PCM - MHFD Detention Calcs 2.pdf Markup Summary

95 (1)

DETENTION BASIN STAGE-STORAGE TABLE BUILDER

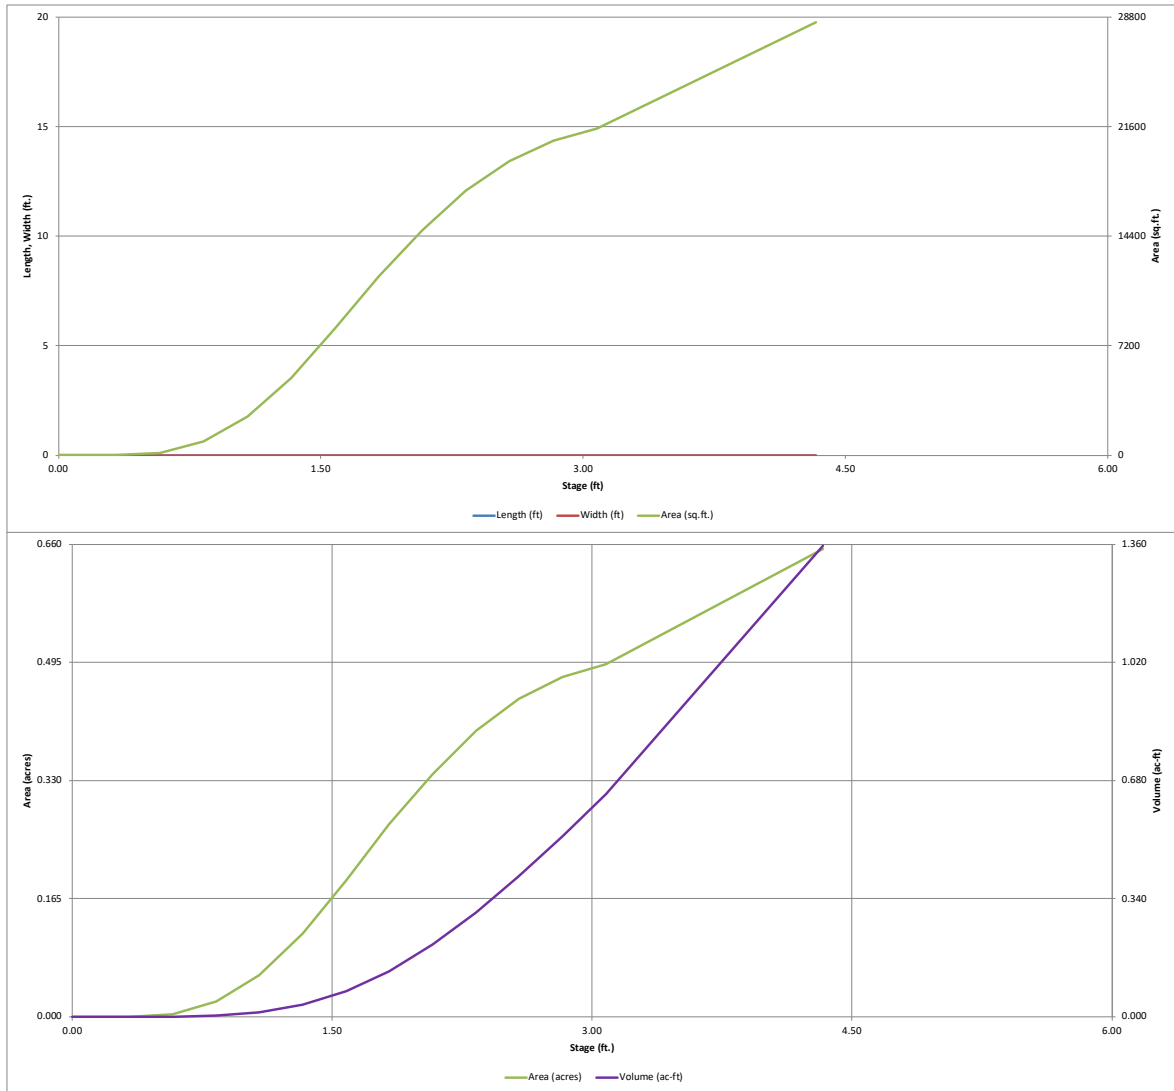
See comments on
DR and address
spillway
discrepancy

See comments on DR and address spillway
discrepancy

DMC RESPONSE: Spillway elevation has been updated in
the GEC to match the DR
